CLEAR VIEW INDUSTRIAL PARK, FILING 2B

GRADING, STORM AND EROSION CONTROL PLANS

PCD FILE NO. SF2029

Figure 13-12c. Emergency Spillway Protection

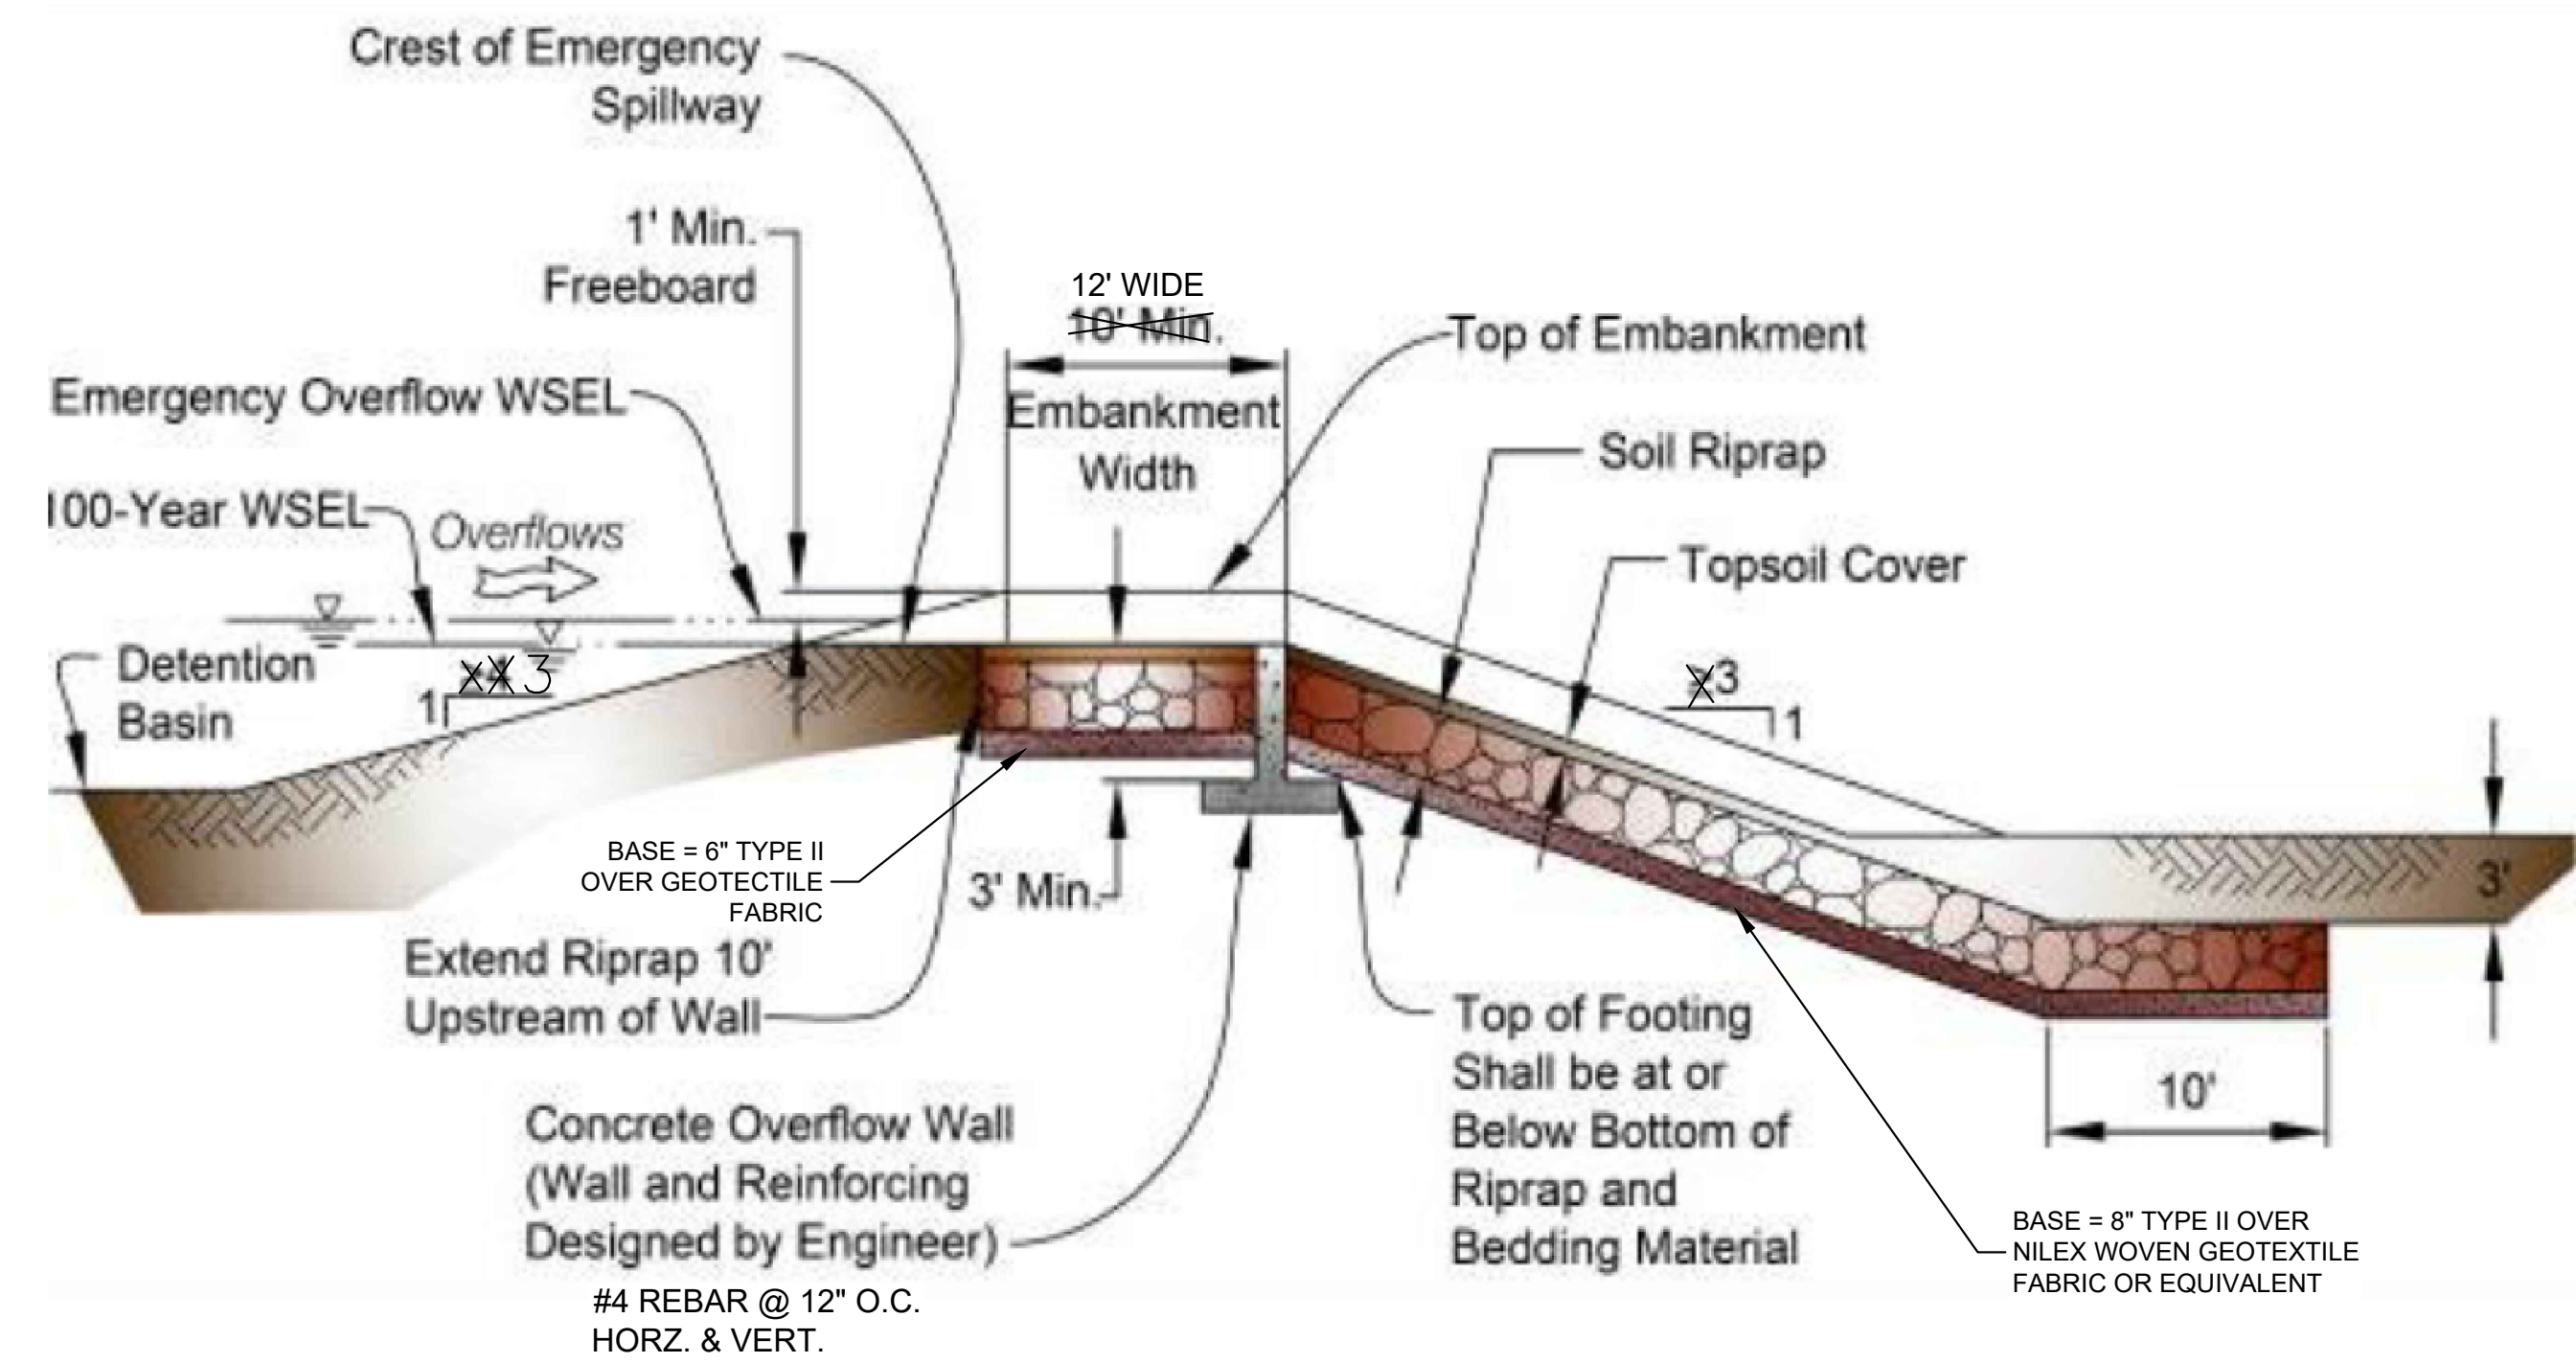
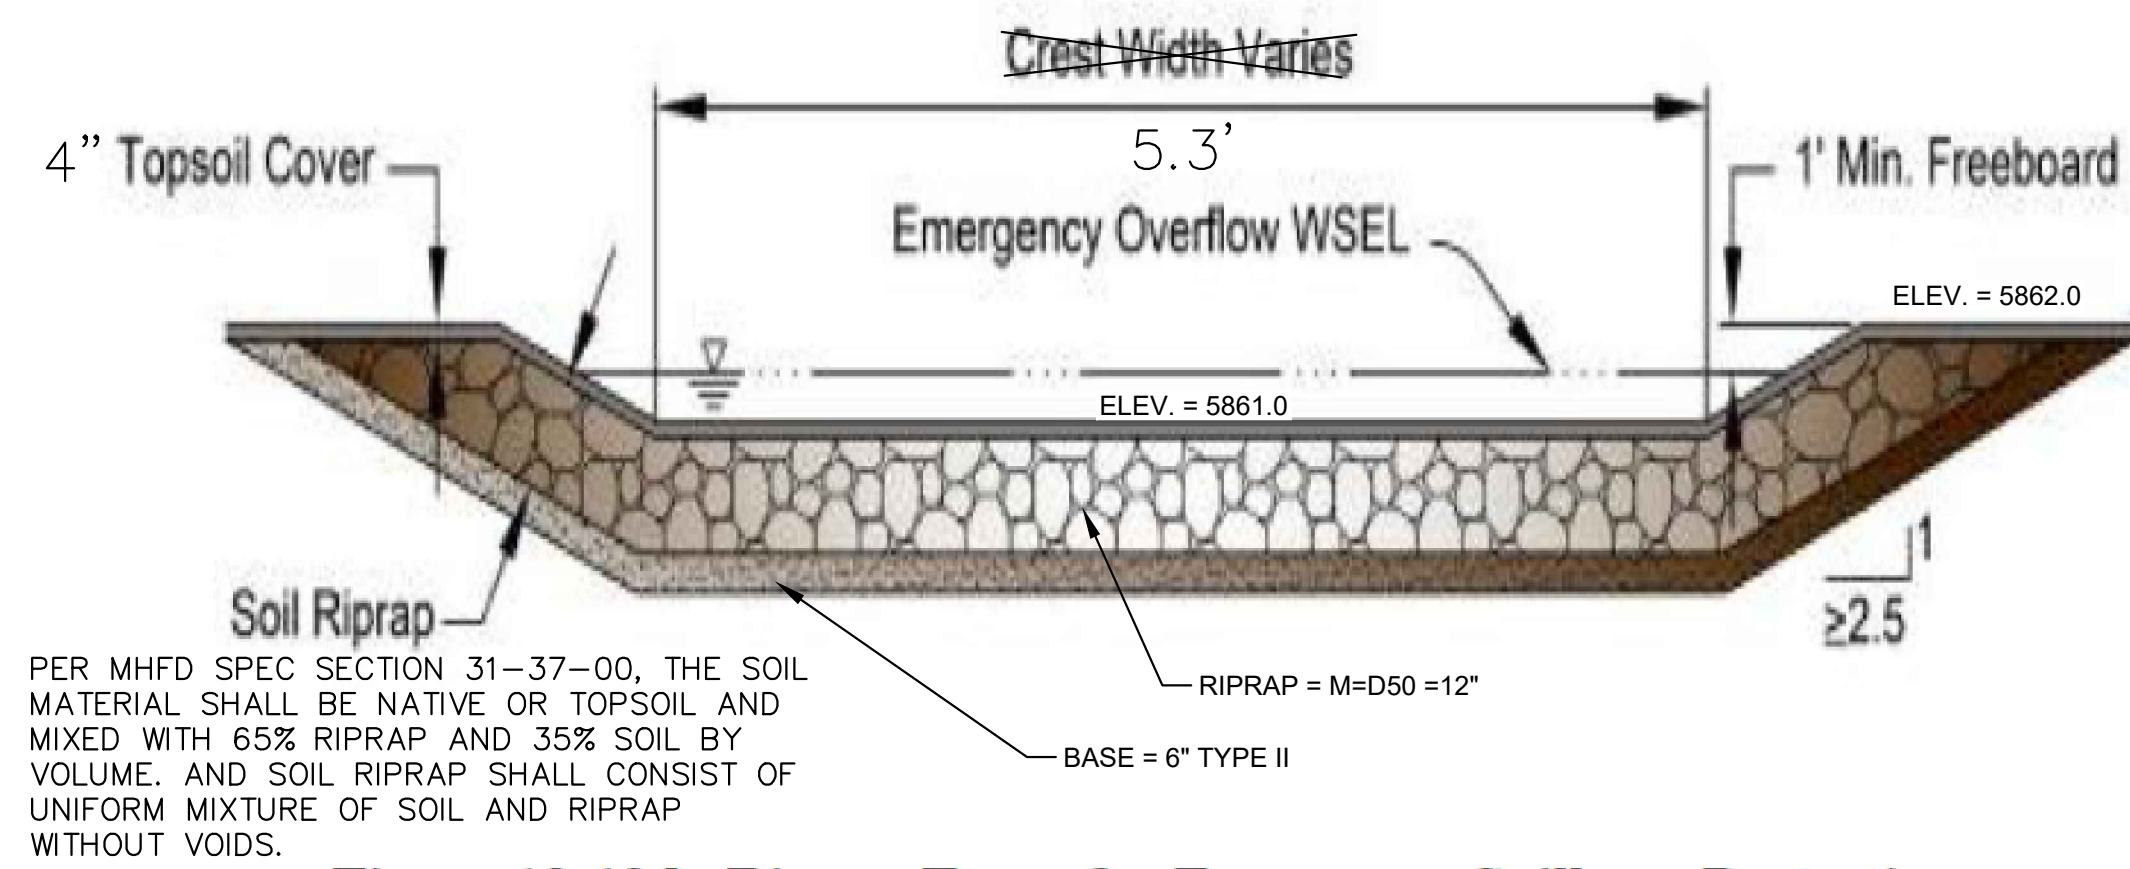
Please revise. Construction drawings as sheet 6 shows a width of 10.3'.

| NO. | DATE | DESCRIPTION | BY |
|---|------------|--------------------------|----|
| SHEET TITLE: OUTLET BOX DETAILS | | | |

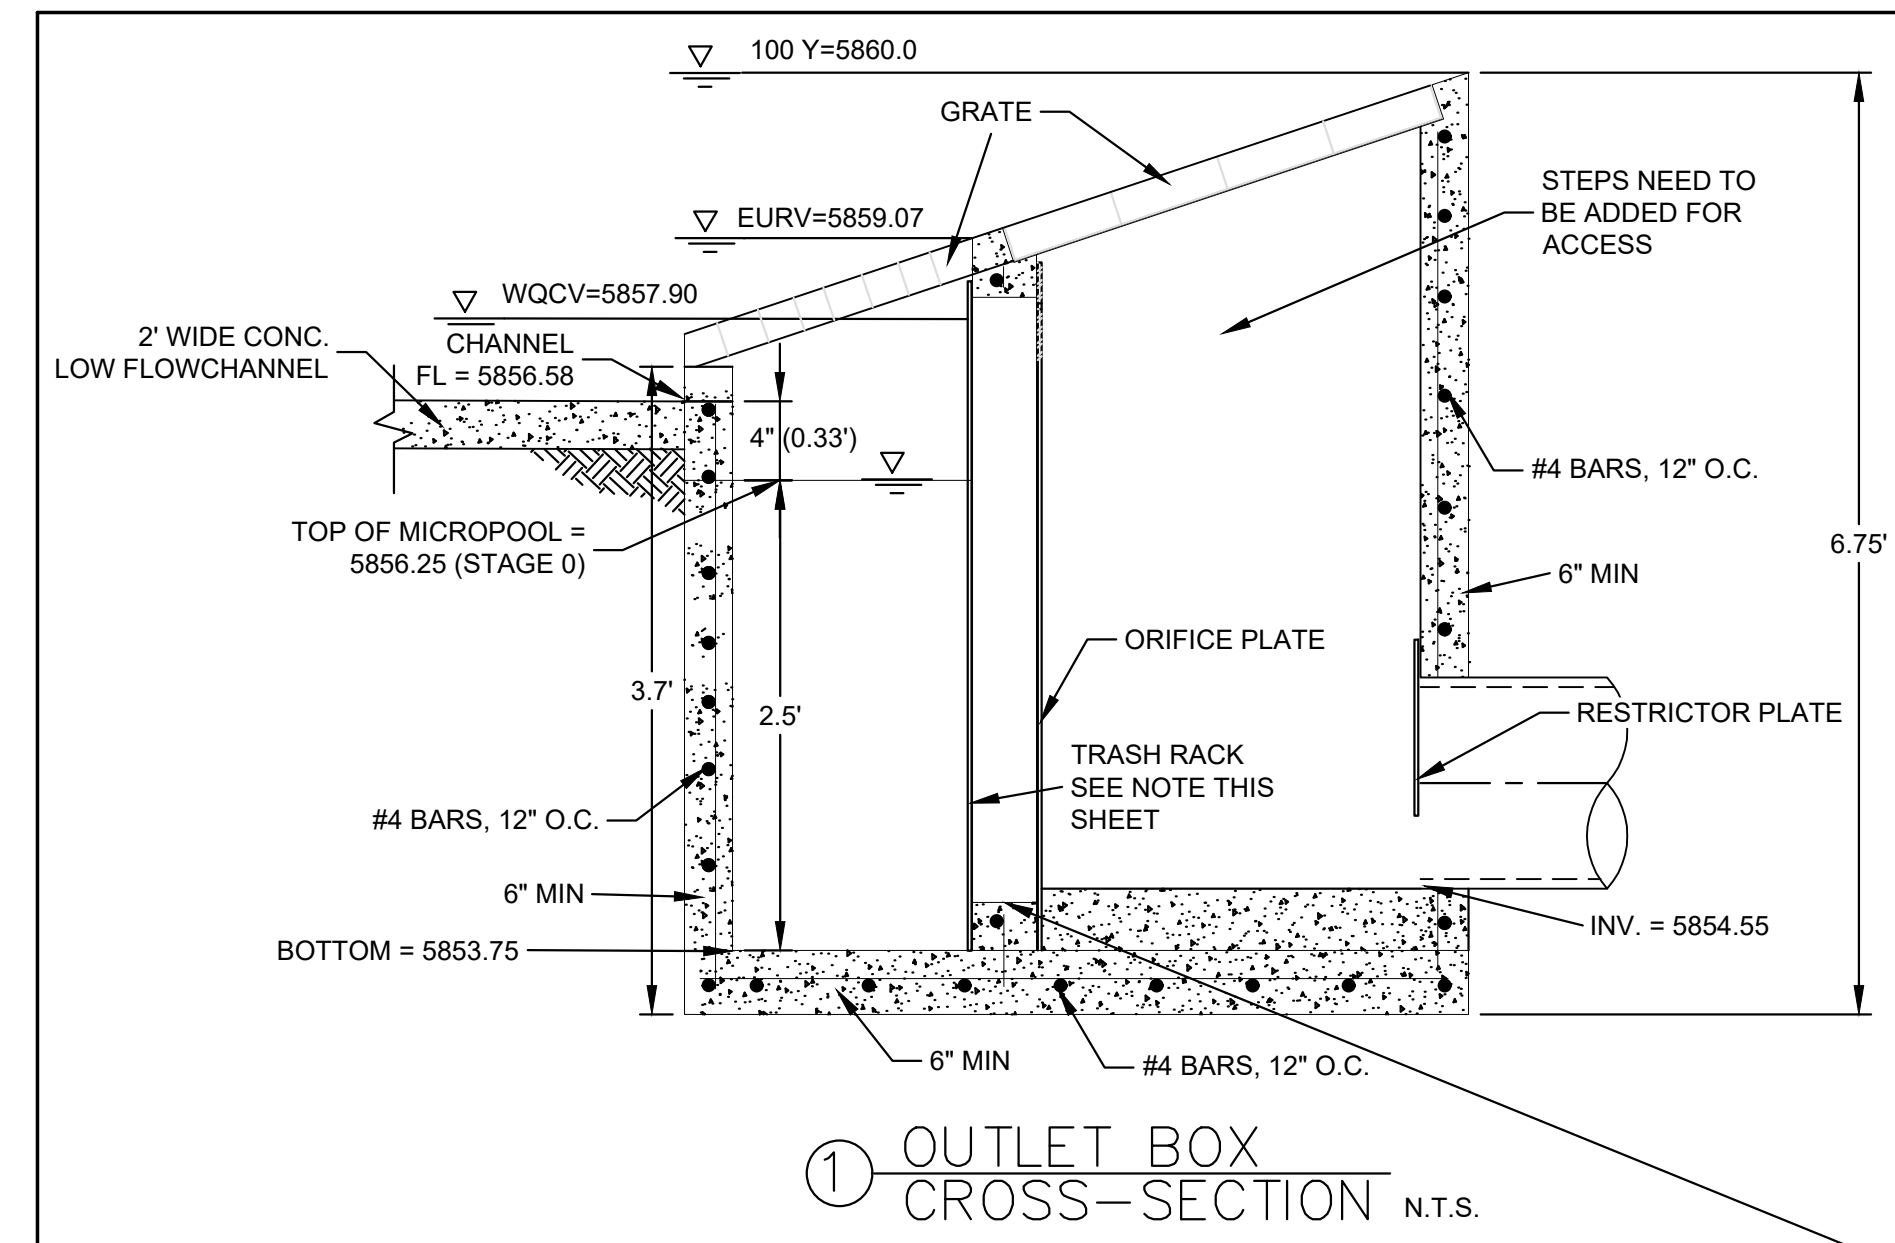
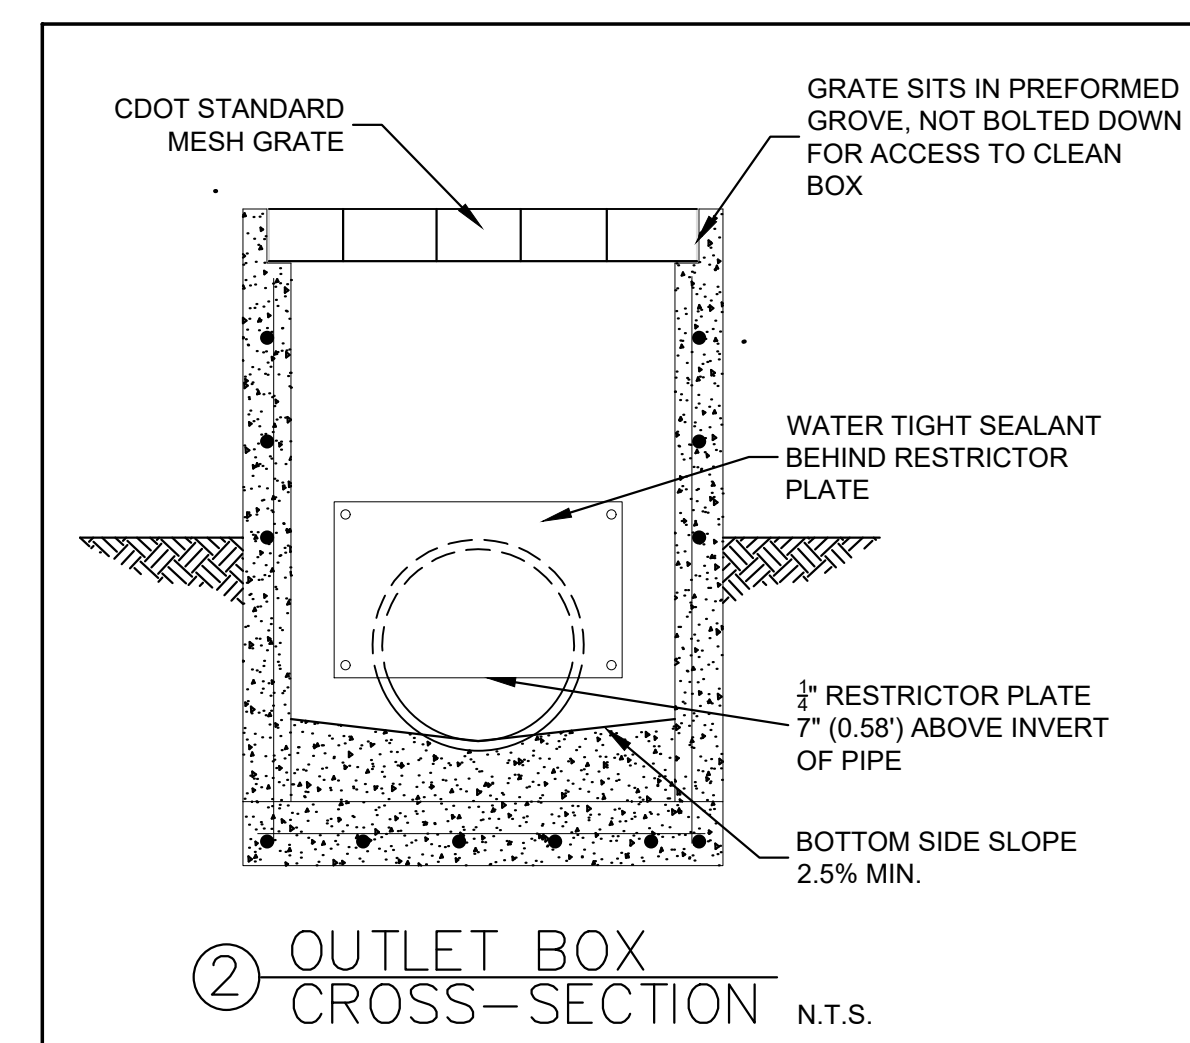
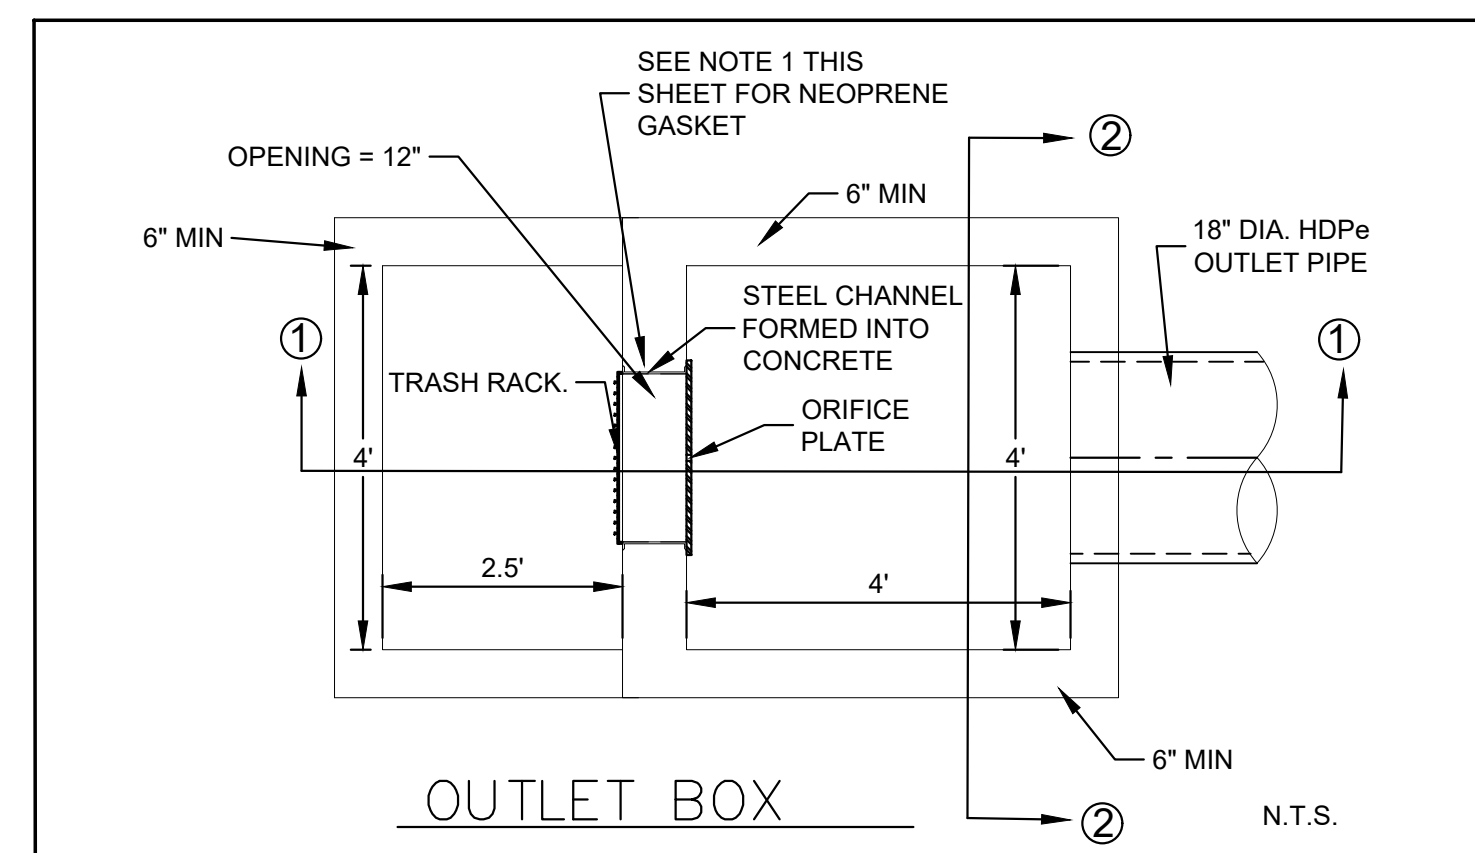
Show Orifice plate above all concrete, such that it does not get embedded in the concrete, so it can be removed for maintenance.

Show a 2.5% min slope in this left to right direction per page OS-9 of MHFD detail T-12. This is in addition to the sloped sides that you already show in Section 2 below.
